From: Laura Gibbons <Laura.Gibbons@arun.gov.uk>
Sent: 16 November 2021 09:37
To: Planning.Responses <Planning.Responses@arun.gov.uk>
Subject: RE: Planning Consultation on: BE/121/21/RES

Engineers Comments Regarding Surface Water Drainage

Application No: BE/121/21/RES

Site Address: Unit 3 Land At Salt Box West of Shripney Road Bognor Regis PO22 9NW

HYDROCK PROJECT NO. C-13319-C		SCALE @ A1 1:250
STATUS DESCRIPTION TENDER		STATUS D2
DRAWING NO. (PROJECT CODE-ORIGINATOR-ZONE-LEVEL-TYPE-ROLE-NUMBER) SAL-HYD-PH3-ZZ-DR-C-7010		REVISION P03

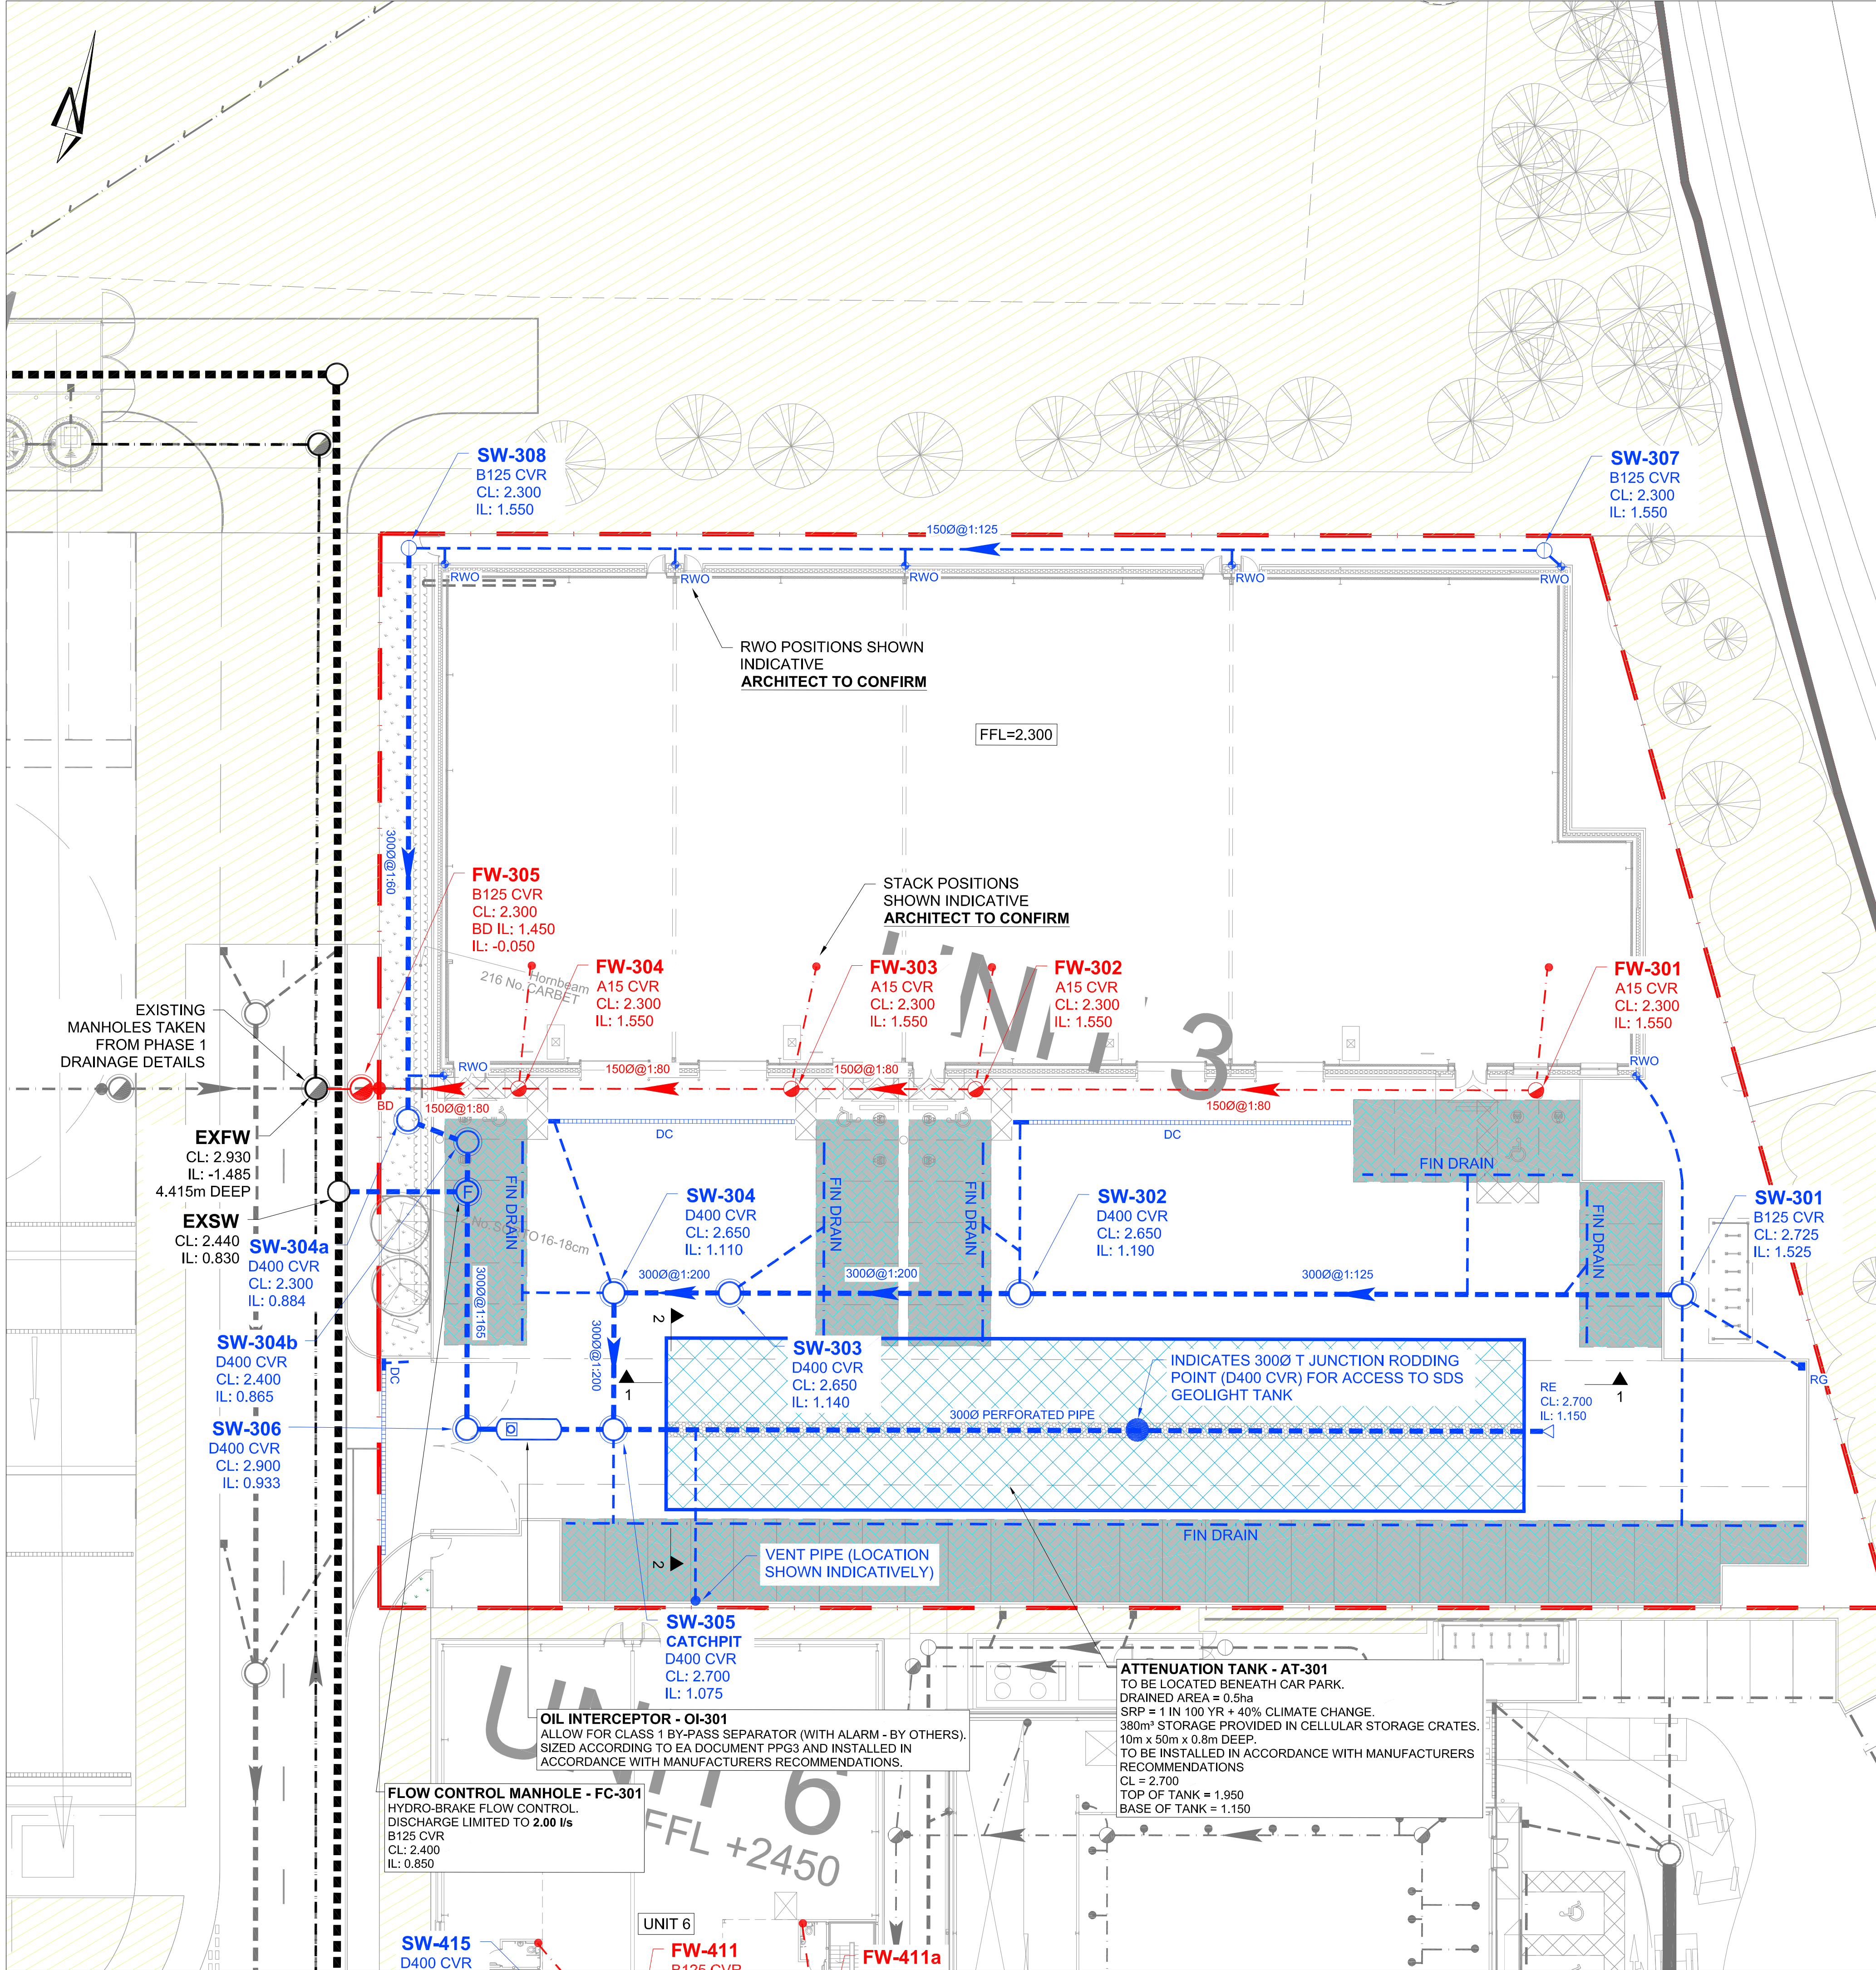
We note that the planting plan has the proposed Sorbus tree in a different location to the landscape and drainage plans. Plans should be consistent. Once again we would suggest that the tree is relocated to remove the conflict with drainage, rather than relying upon root barriers. If the tree is retained in the proposed position the root barrier extents shown are insufficient, and would have to extend on the western and southern sides too.

We will need evidence to be submitted to show that the root barrier will extend to adequate depth.

Please DO NOT list the drainage plans as approved under this application.
